The Keadby Next Generation Power Station Project

The Keadby Next Generation Power Station Development Consent Order [year]

Applicant's Comments on Relevant Representations

Figure 14.7.2a Representative Viewpoint
Viewpoint 2a: Gate Keepers Residence, Vazon Bridge, Keadby

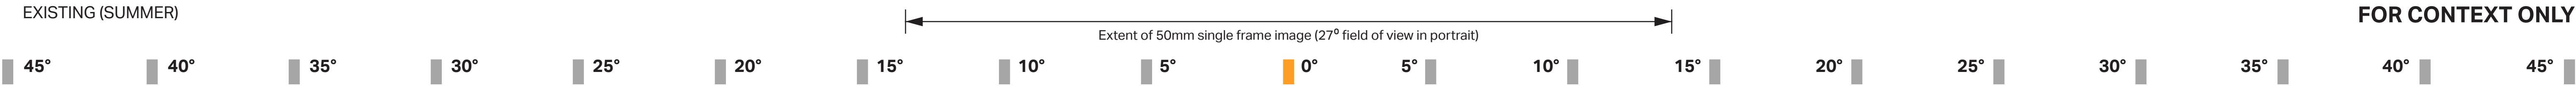
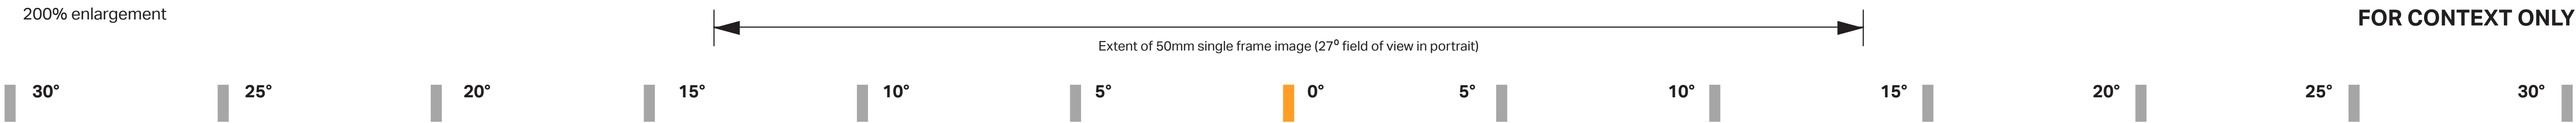
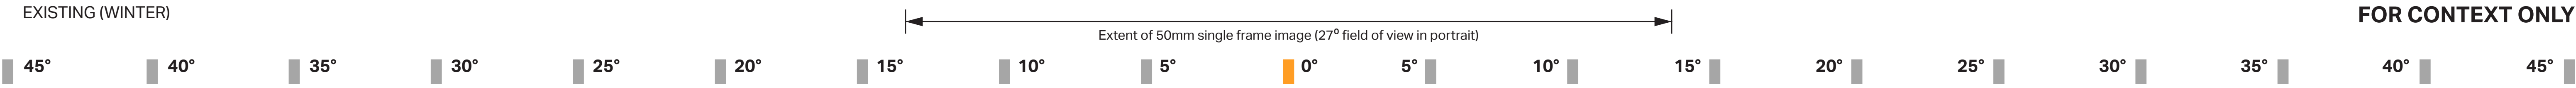
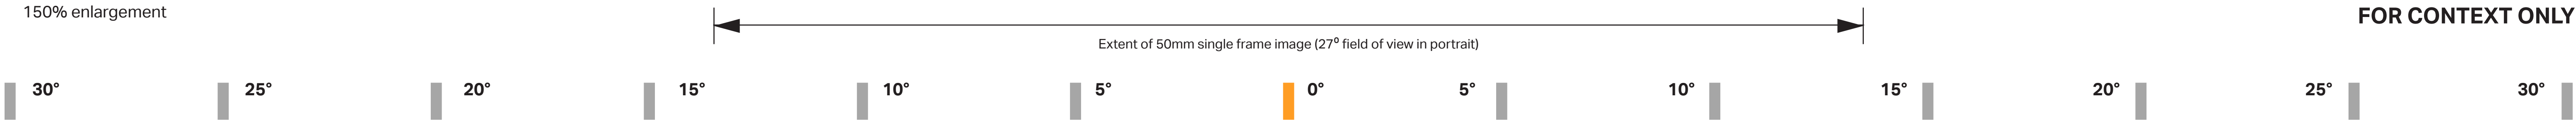
Visual Impact on the Canal: The Landscape and Visual Impact Assessment (LVIA) [APP-048] and baseline views confirm that the primary issue for the canal concerns the loss of amenity for recreational users. Existing trees play a role in screening the lower parts of the power station, a positive, natural quality of the canal side, which helps reduce the prominence of outward views towards the power plant complex. We acknowledge that the upper sections of the Keadby 1 and 2 power station structures are prominent and visible, as shown in views 2, 2a, and 14. There are also visible areas of infrastructure directly along the canal side.

The Project would include the loss of established trees to the west of the abstraction site. Section 14.7.2 of the LVIA [APP-048] states that “It is considered that the addition of landscape features such as trees and woodland would not be effective in reducing these effects on visual amenity.” However, we believe that this is inaccurate, as observations on site by the Trust at this location highlight that existing trees and vegetation

effectively soften the impact of the extensive infrastructure at lower levels from the canal side; and replanting trees would achieve the same positive benefit.

We therefore request that it is ensured that replacement trees are incorporated in this location. The Trust would need to review a further landscape plan of the proposed planting locations if they differ from the current location. Any new trees would need to be native, be able to effectively soften the development, and require root protection to prevent damage to infrastructure.
